Modification 1 Temporary Water Treatment System (SSD 6666) – Hart Road, Loxford – Cessnock LGA – Request for Advice

BCD's recommendations

BCD's detailed comments

**Figure 2 |** Proposed location of leachate management infrastructure

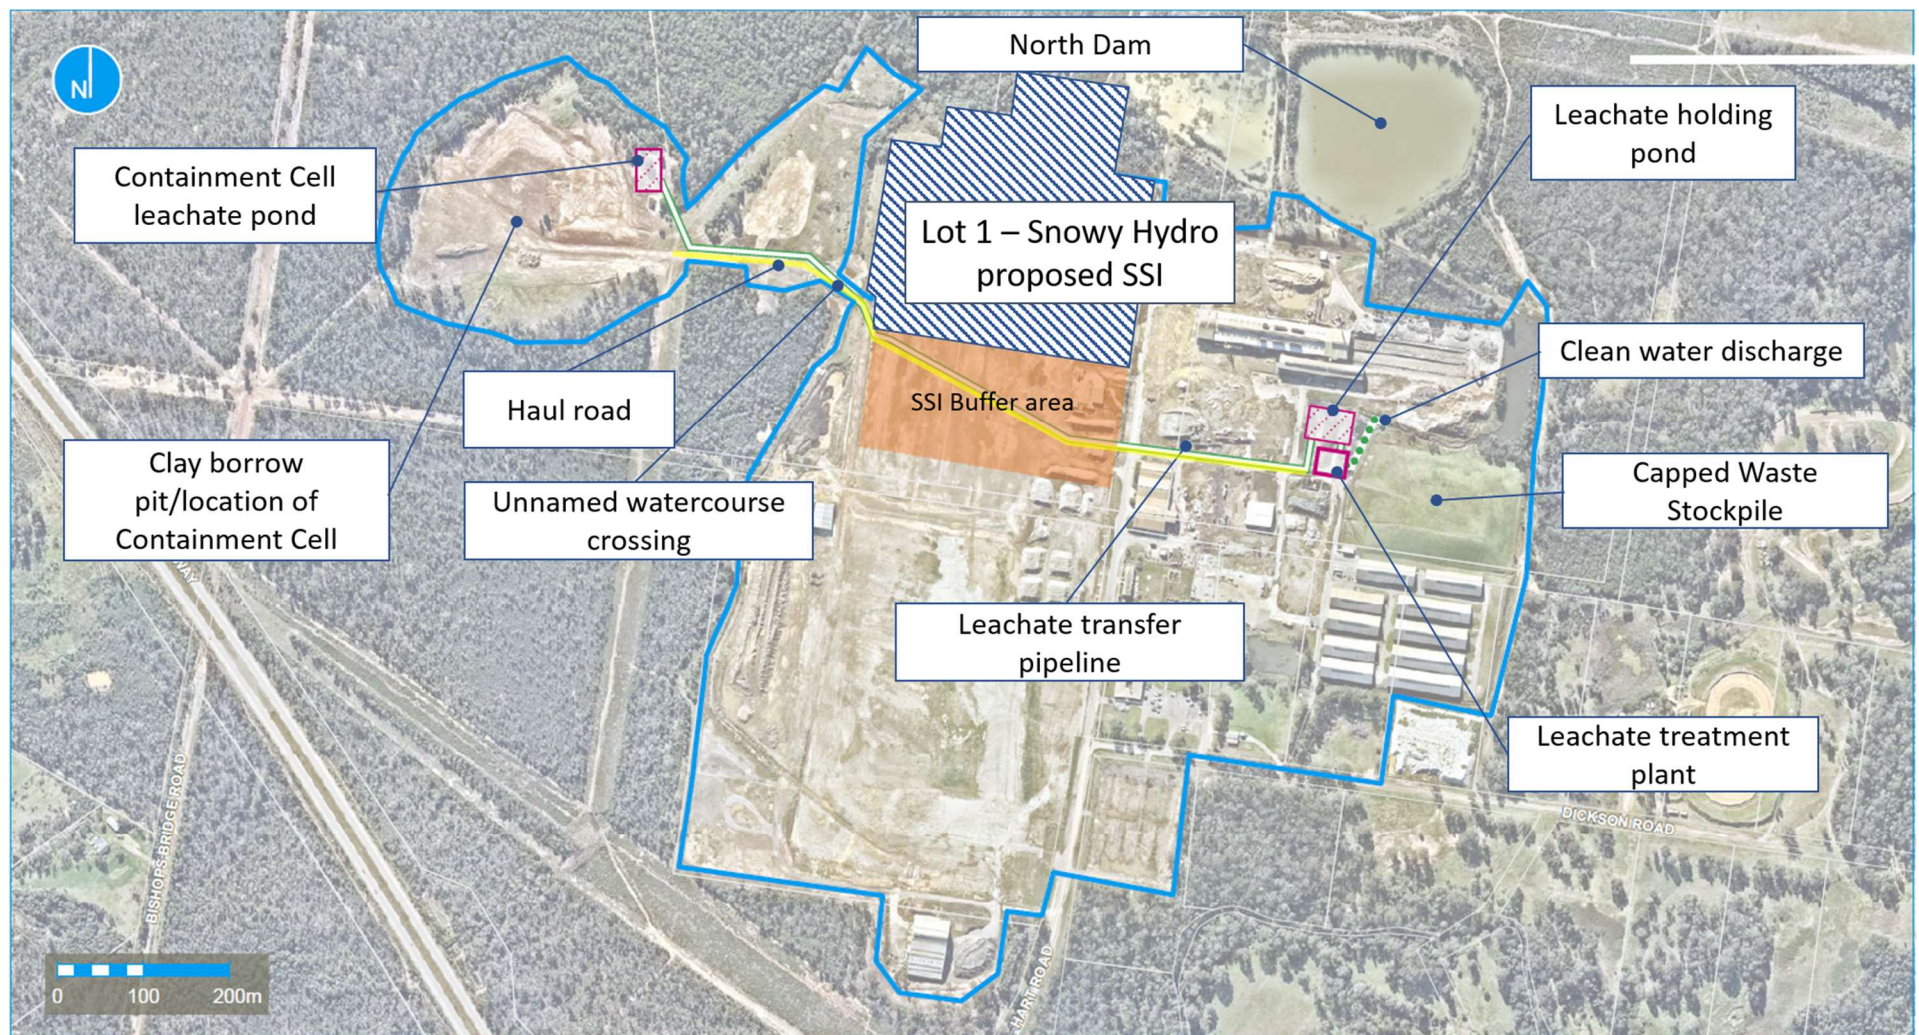
1. There is conflict between the proposed transfer pipe location and the proposed power station proposal

The un-numbered figure included in Appendix 1 – Leachate management plan Dec 2010 shows the proposed location of the on-site treatment system. This plan shows a plastic pipe transferring liquid captured at the containment area across the unnamed creek to the proposed temporary ponds and portable water treatment plant.

The location of the pipe crosses the location shown for the gas fired power plant covered by another major project application (SSI-12590060). An alternative location for this pipeline or an alternative method of transferring this leachate waste to the on-site or off-site facilities is required, unless the power plant does not go ahead. The alternative route may impact biodiversity aspects of the development if it encroaches into previously undisturbed ground.

The proposed transfer pipe crosses the proposed location of another major project. An updated route should be identified and assessed for impacts.
